Our Ref: TR030003

Date: 21 November 2017

Application by Port of Tilbury London Limited for an Order Granting Development Consent for a Proposed Port Terminal at the Former Tilbury Power Station ('Tilbury2')

Advice following issue of decision to accept the application for examination

100
10
0
Millimetres

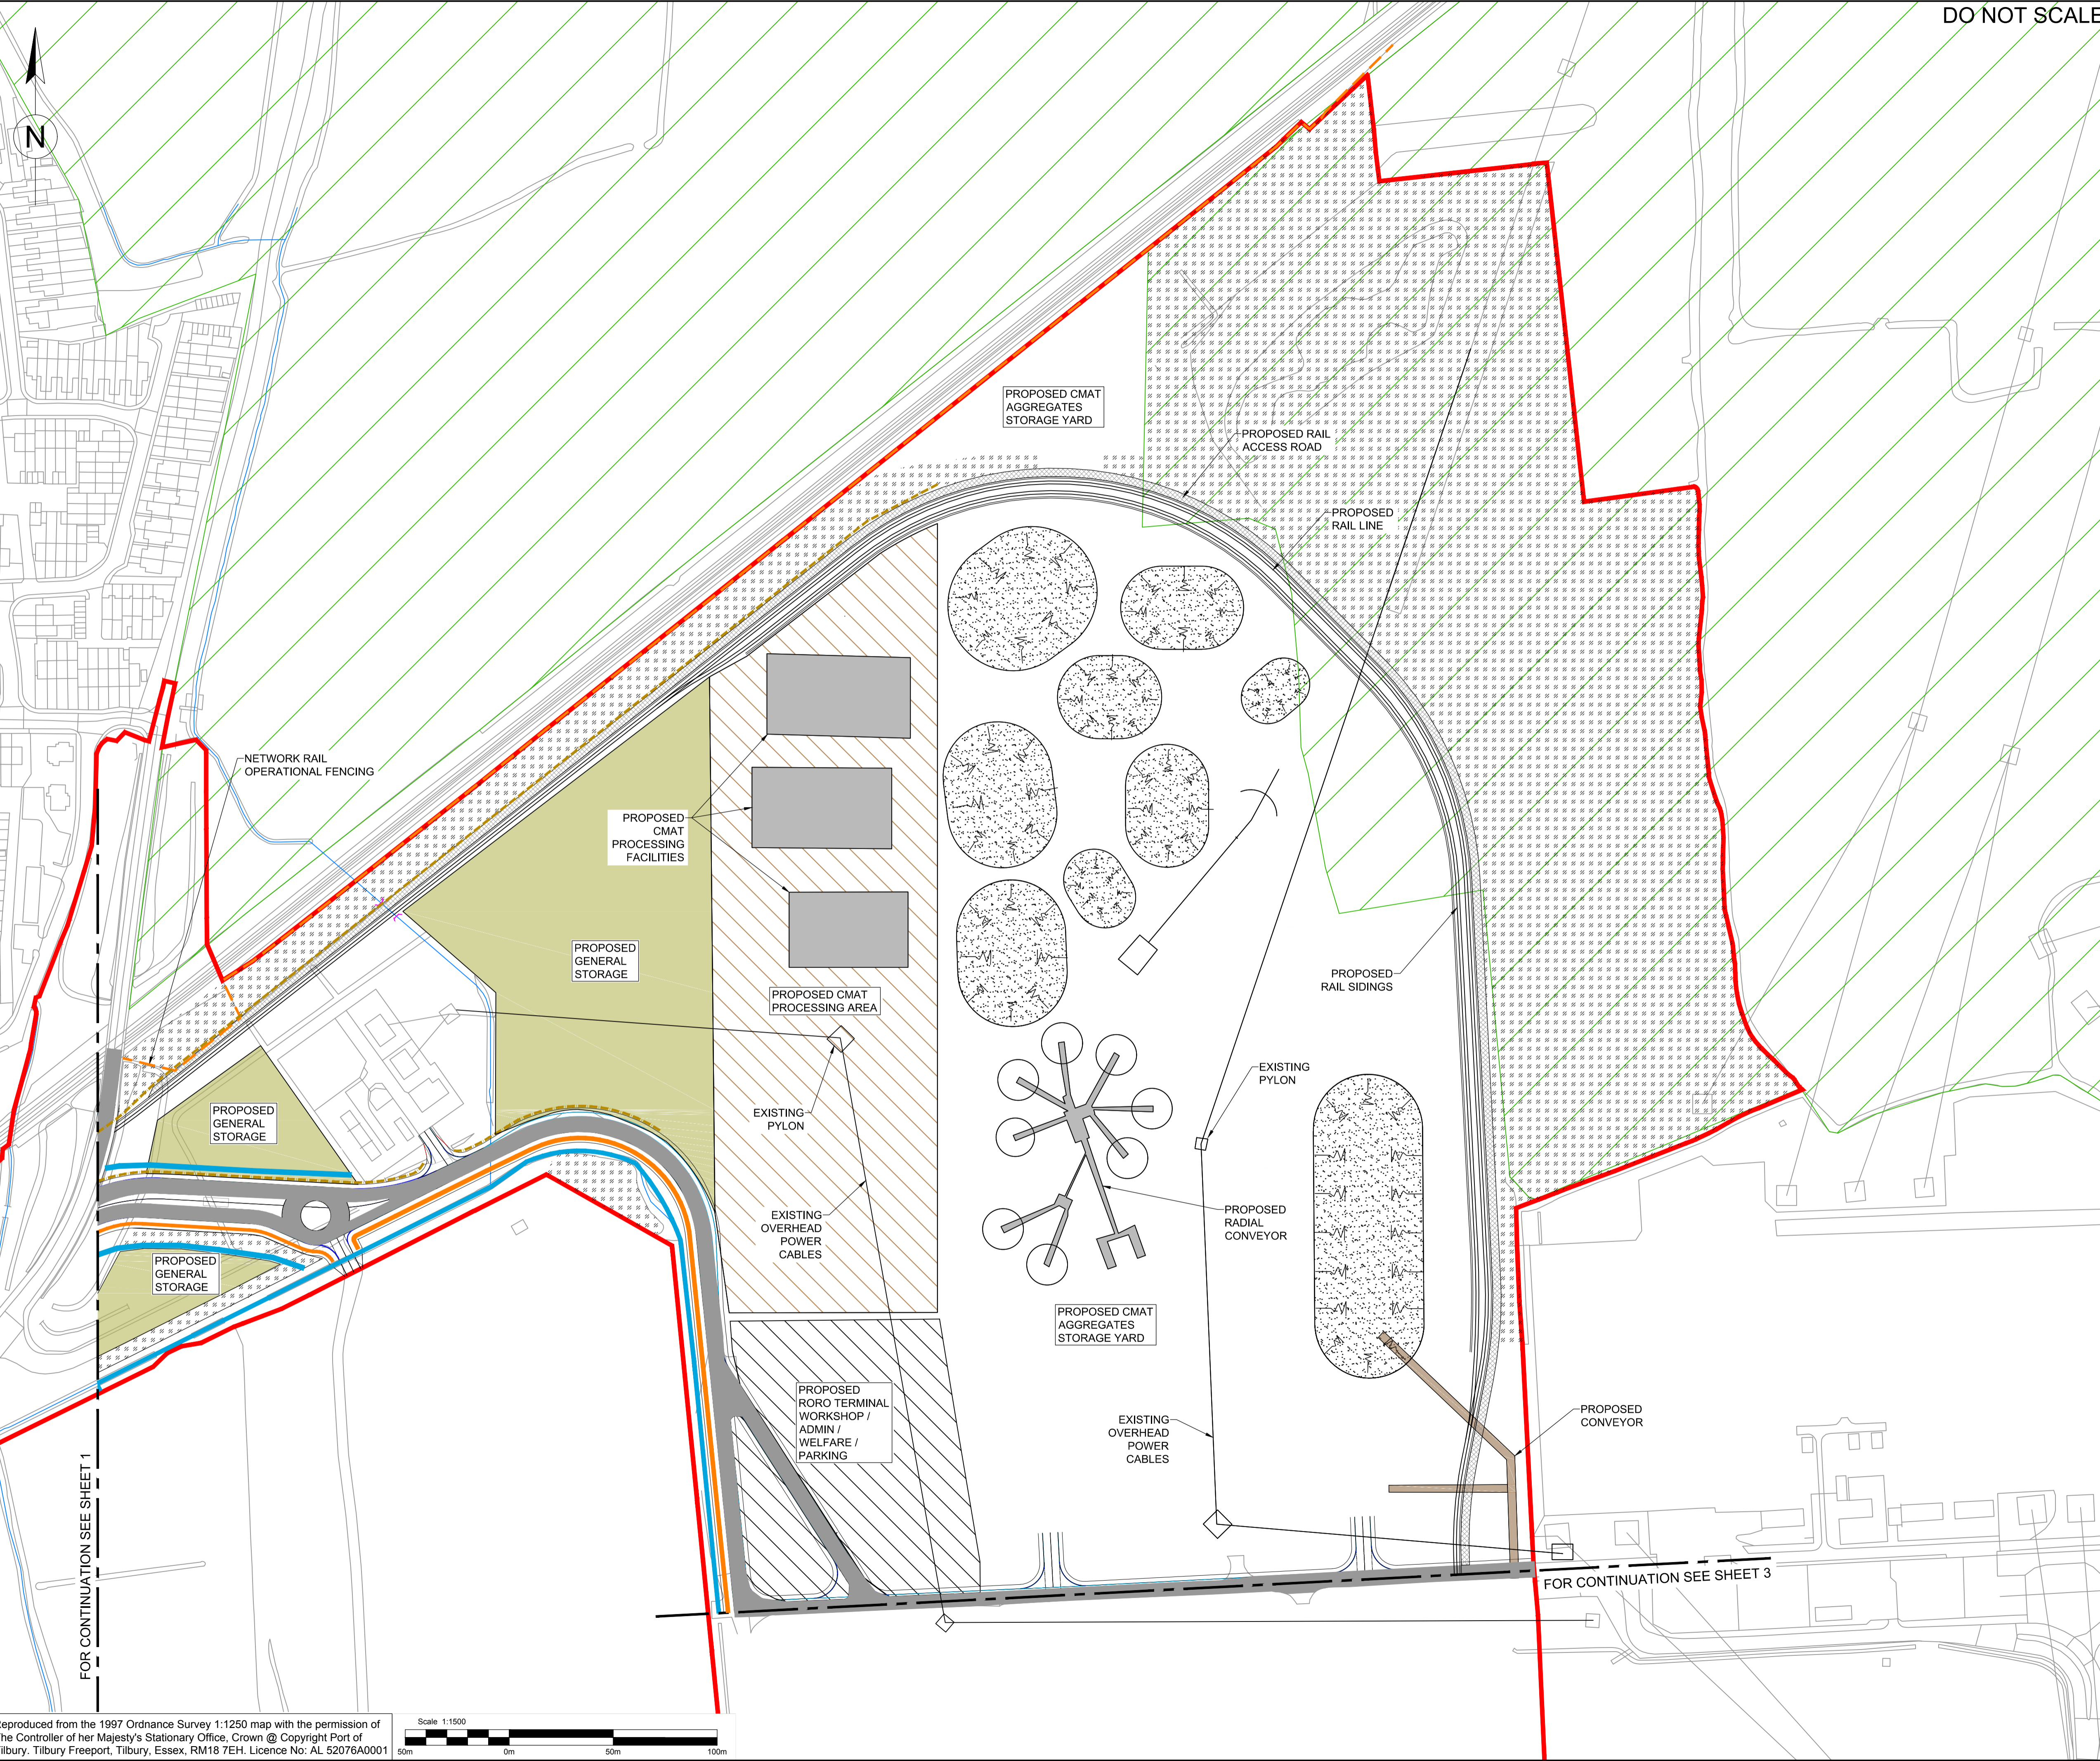
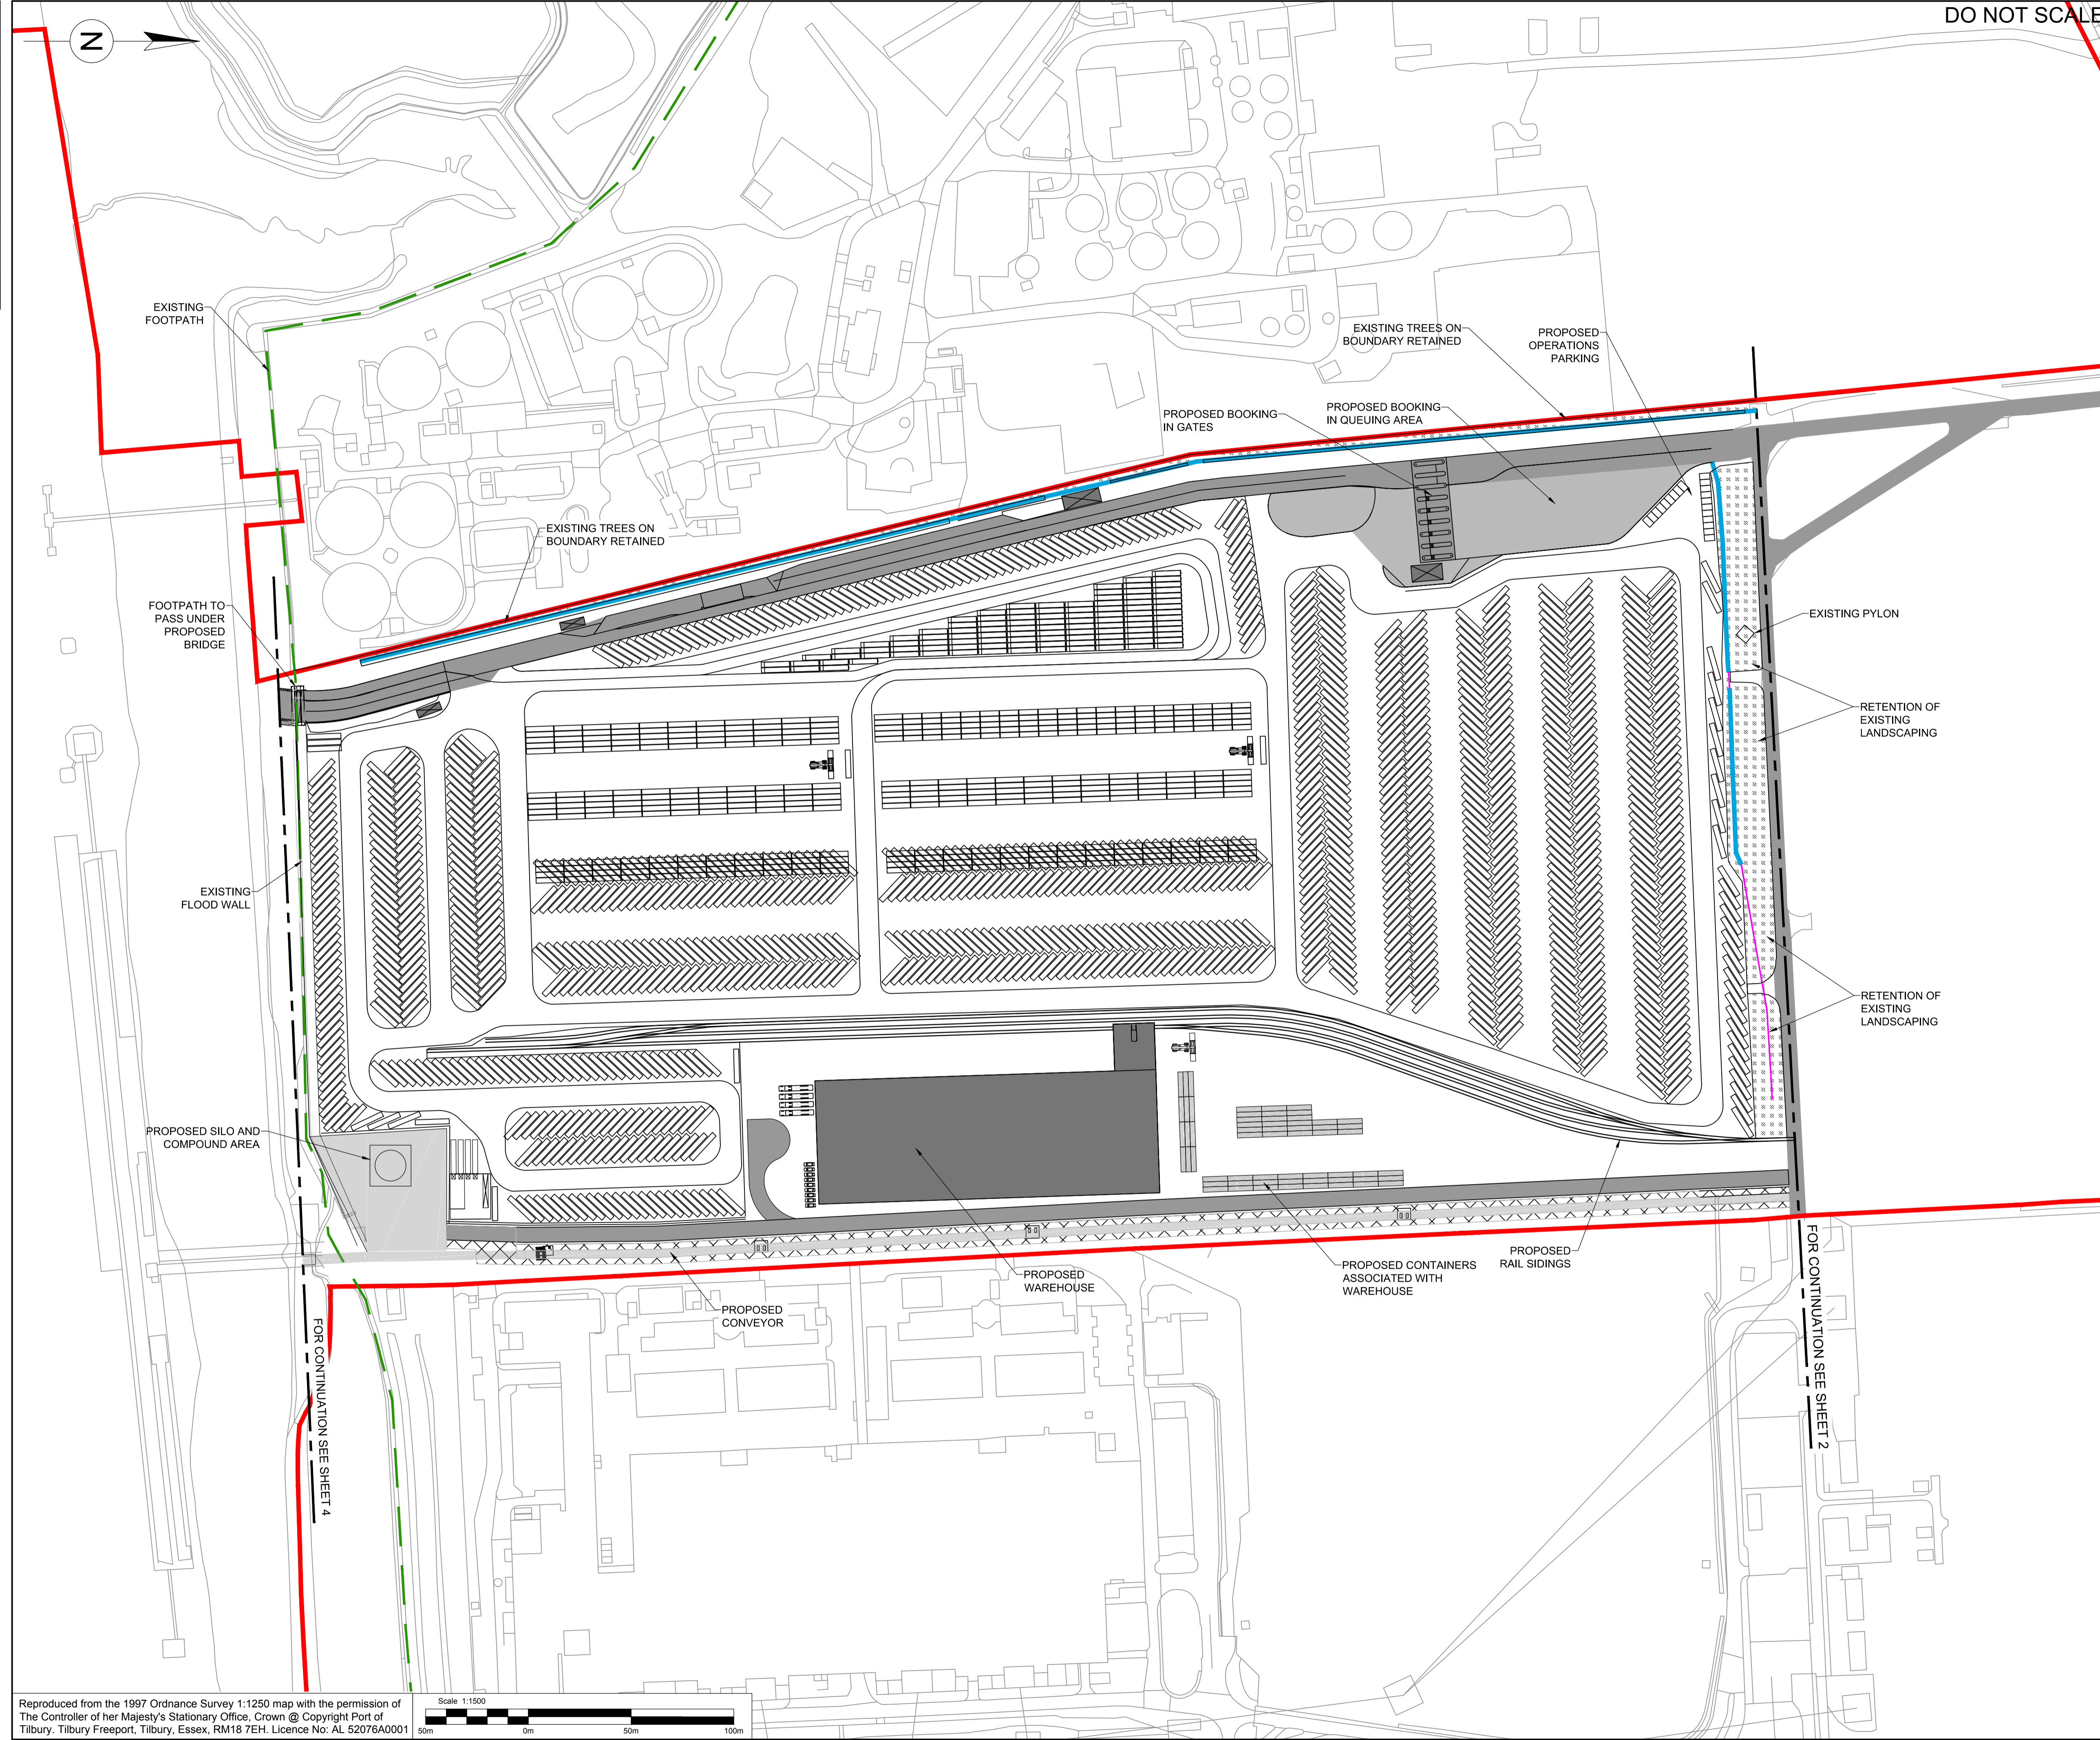
The Engineering Drawings and Plans (Doc 2.9) and the Works Plans (Doc 2.4) state "Do Not Scale". However, they are provided with scale details and a scale bar on each plan. In addition the General Arrangement Plans (Doc 2.2) and Engineering Drawings and Plans state, "Design shown is for illustrative purposes only", (or similar wording). We note that the Engineering Sections and Plans would become a certified document, should the DCO be made. In accordance with APFP Regulation 5(3), a scale is to be provided on these plans and drawings, and the Applicant should prepare for any questions the Examining Authority may have on this point.

Work No.1 includes the alteration and renewal of an existing flood defence. The existing flood wall is identified on the general arrangement plans; however, it is not clear from these plans precisely where the works would take place. Figure 6-3 of the Level 3 FRA (ES Appendix 16.B) contains a figure showing the existing floodwall; however, this figure is not clearly legible. The Applicant should prepare to be asked to revise and submit a new figure(s) to provide absolute clarity including the precise
